**APPROVED**  
Limited liability only. Permit holder responsible for full compliance with the code.

02/26/2024

Addition & Renovations to  
**The Turlington Residence**  
 Sheet Title  
**Existing Conditions**

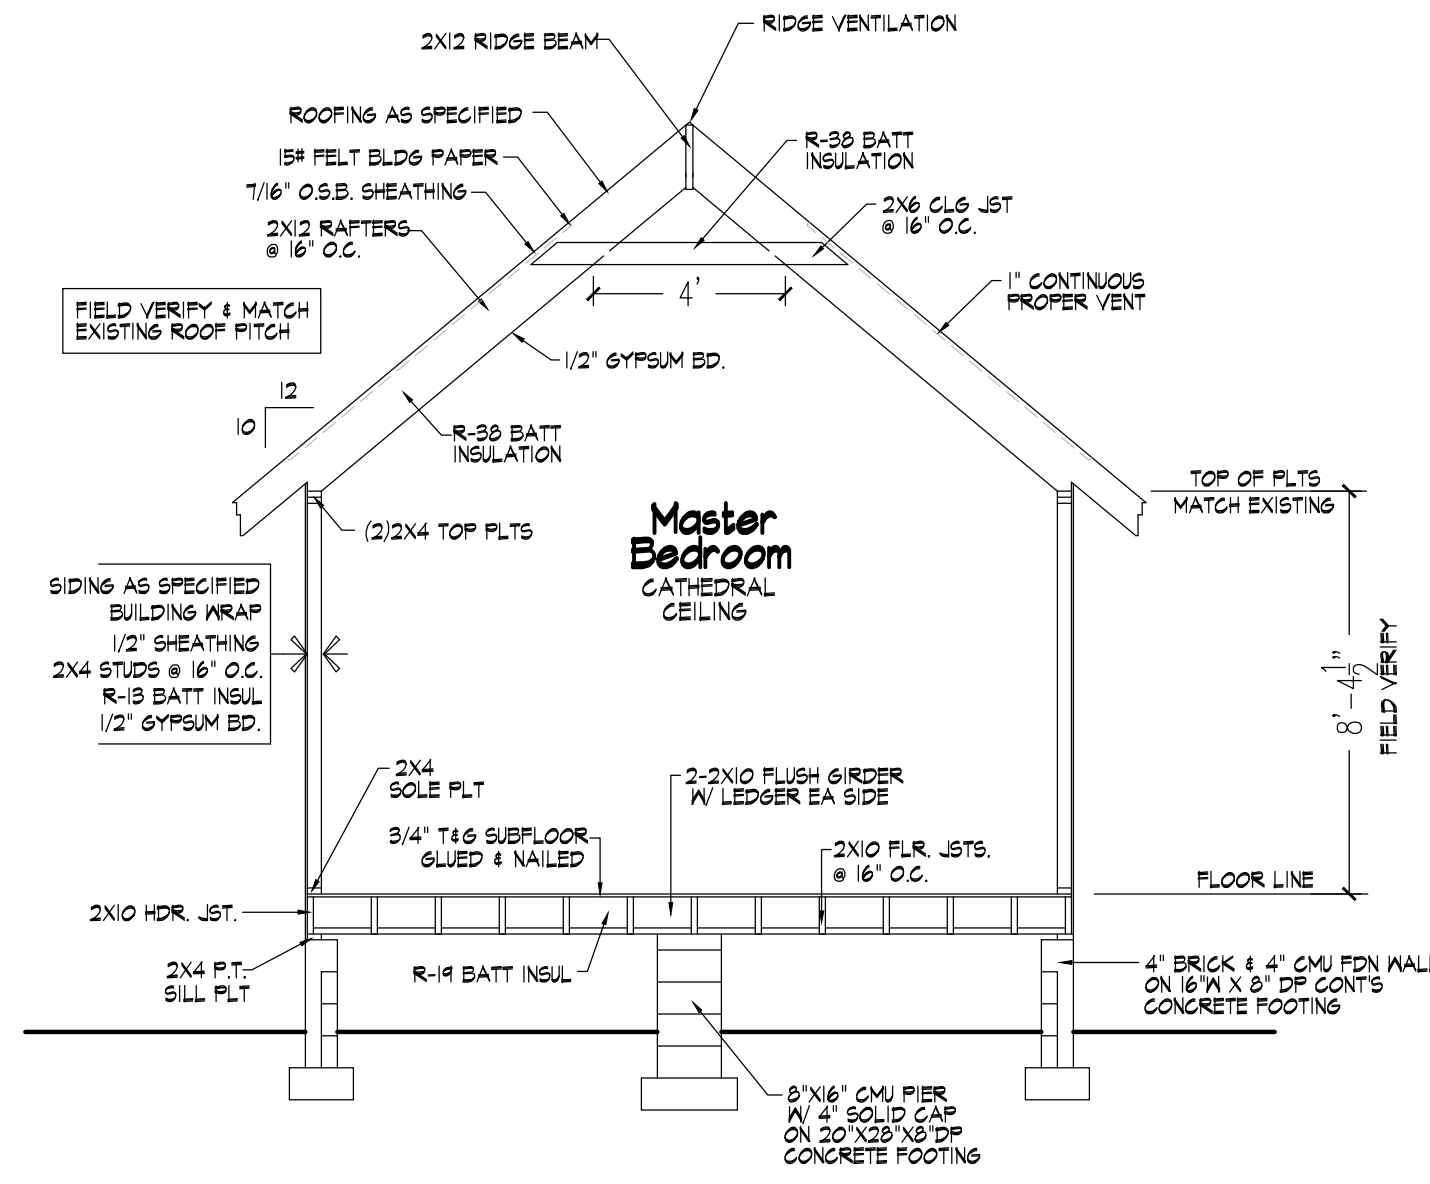
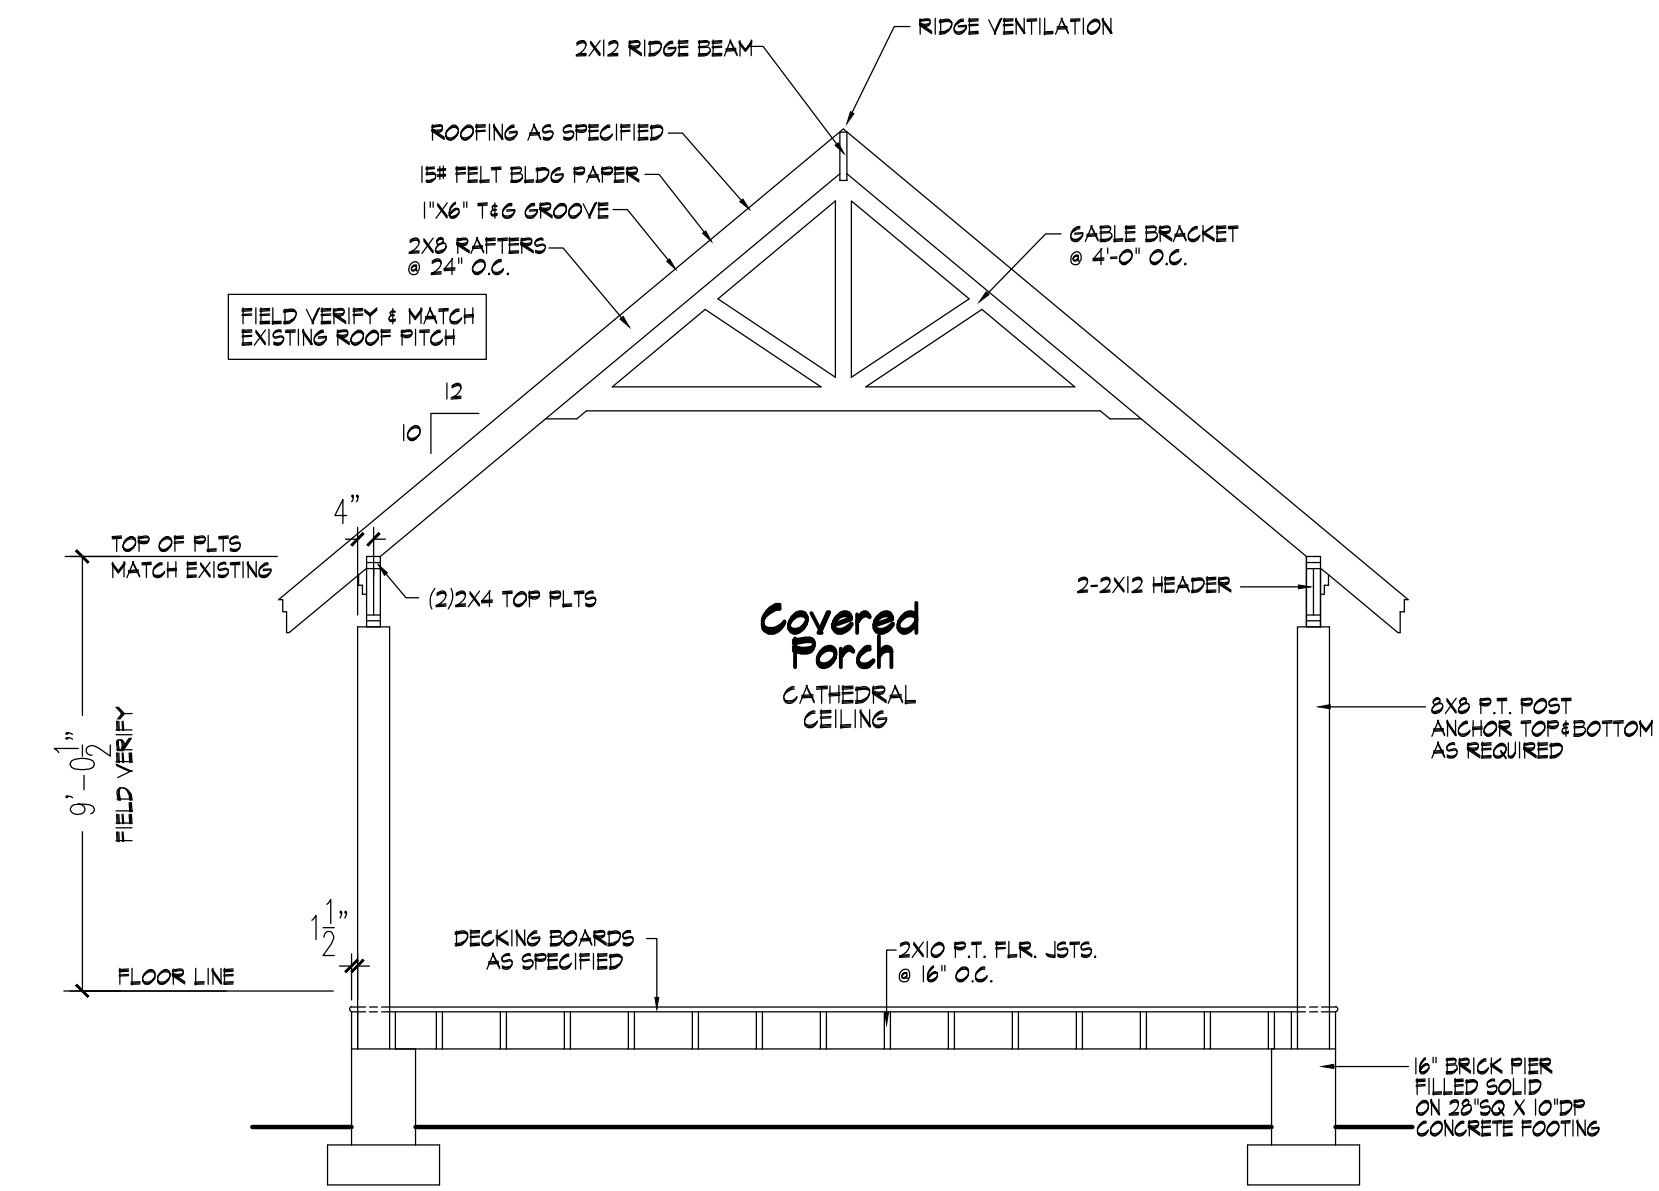
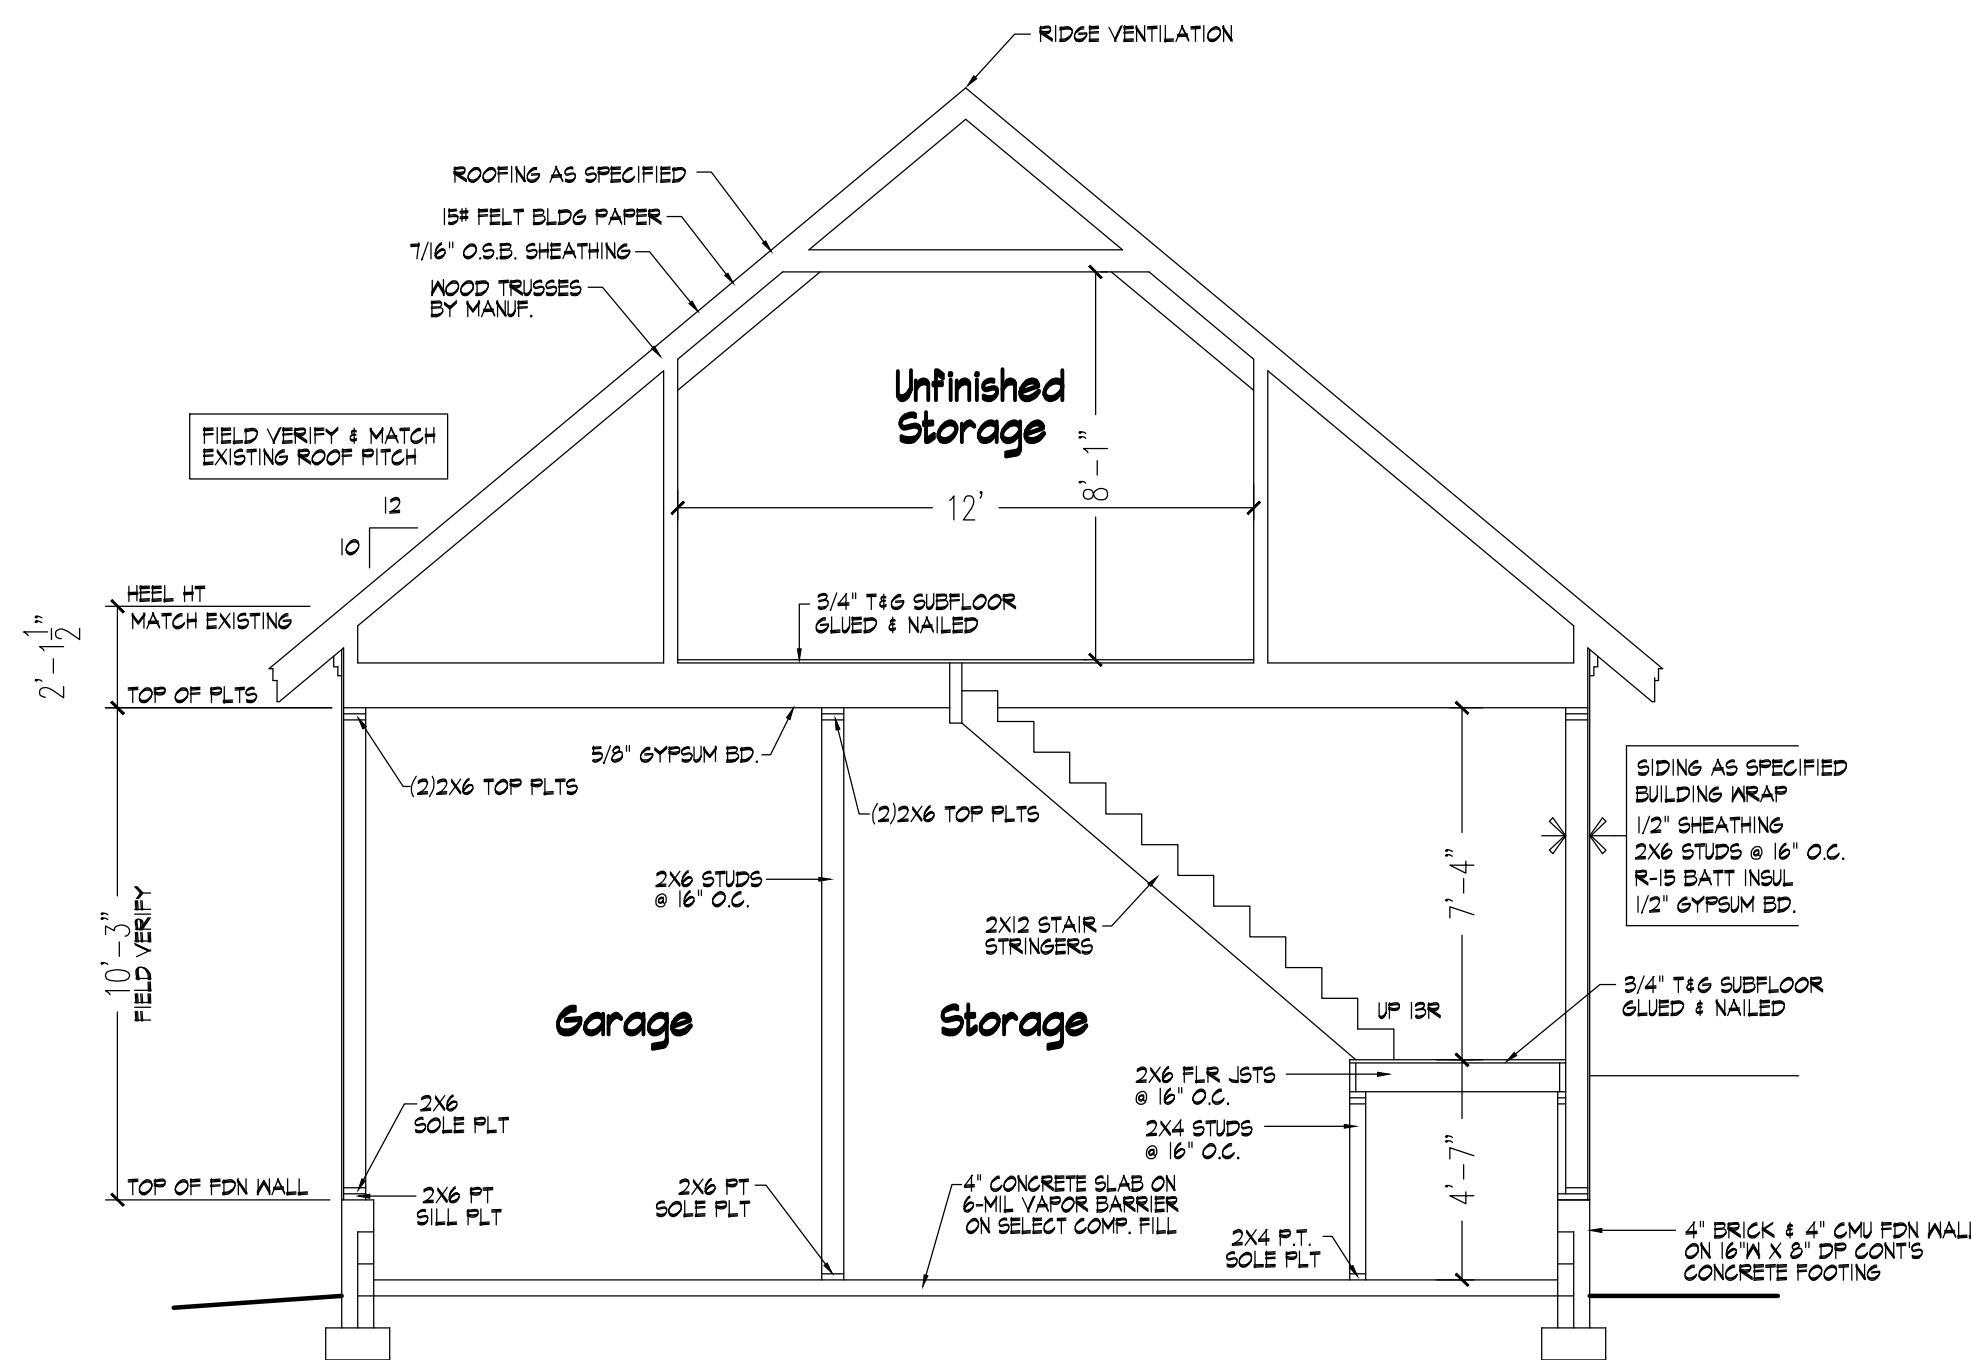
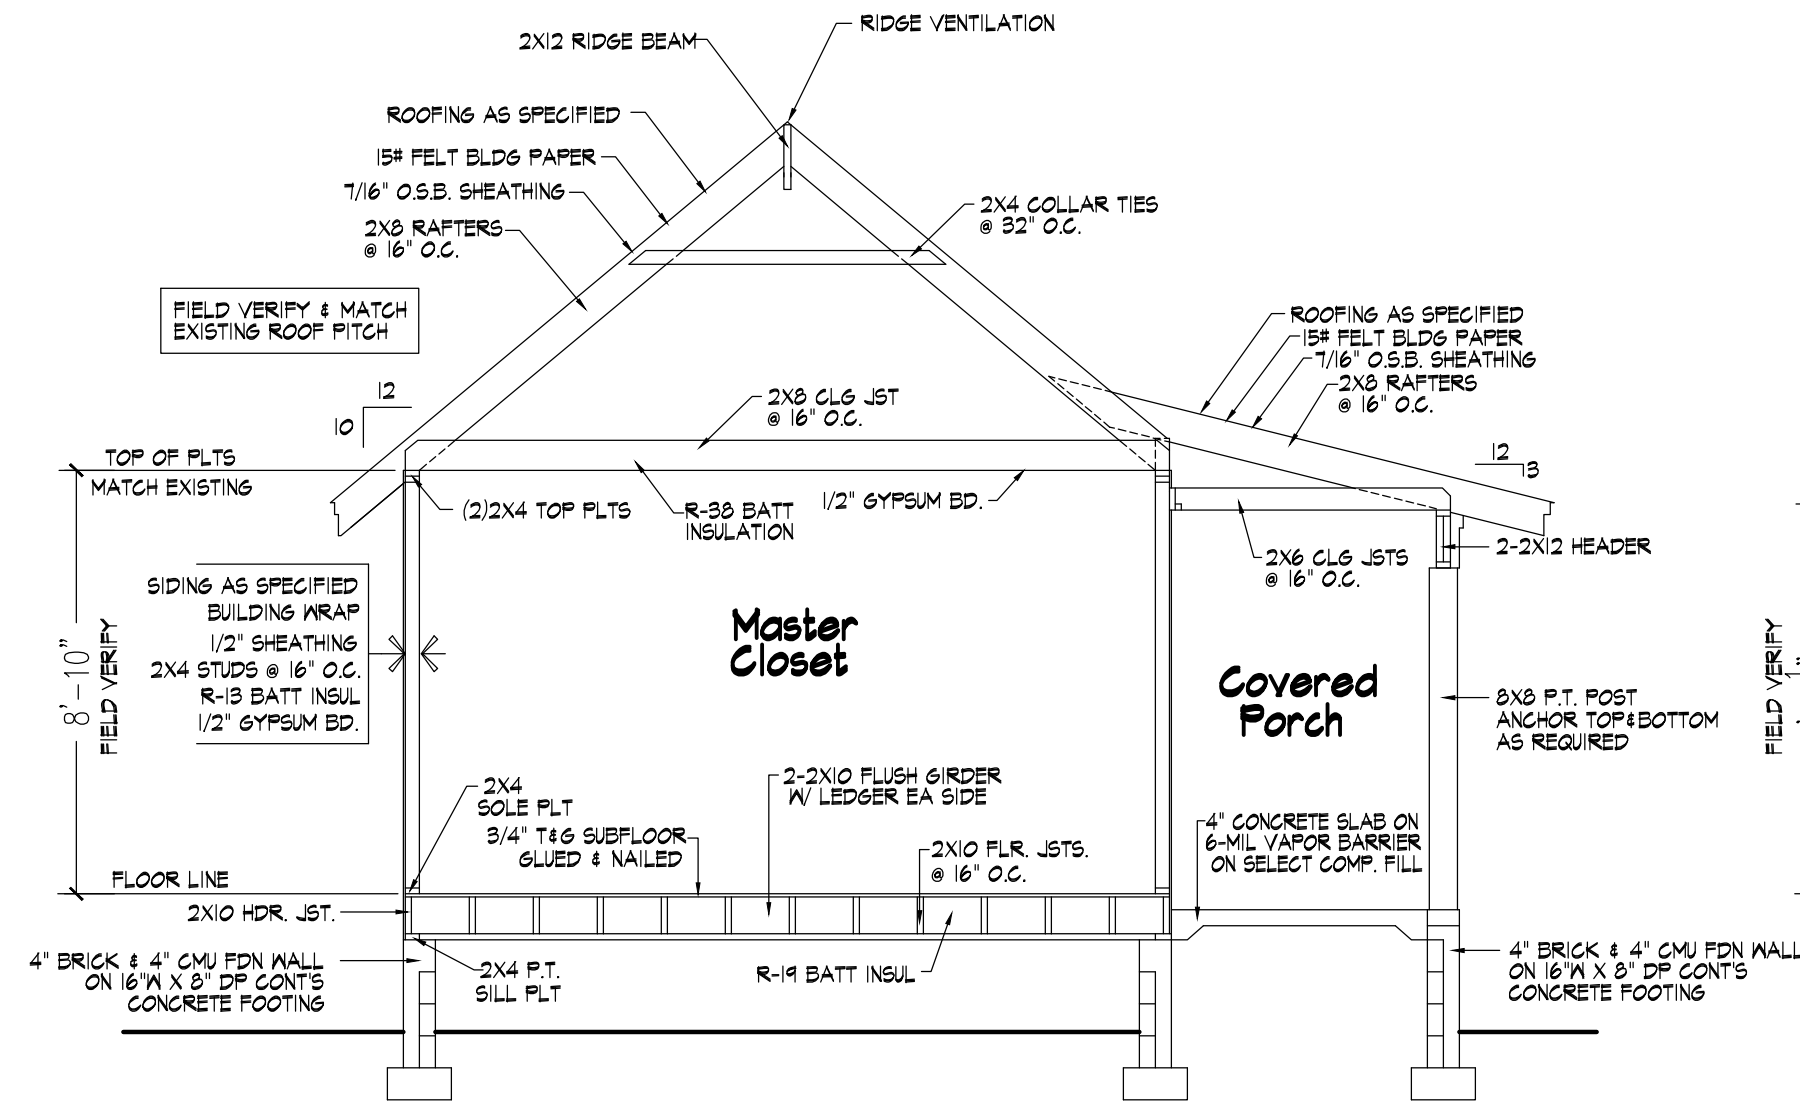
This should be designed as a beam, to support roof load and prevent rafter thrust. Collar ties are not designed to prevent rafter thrust
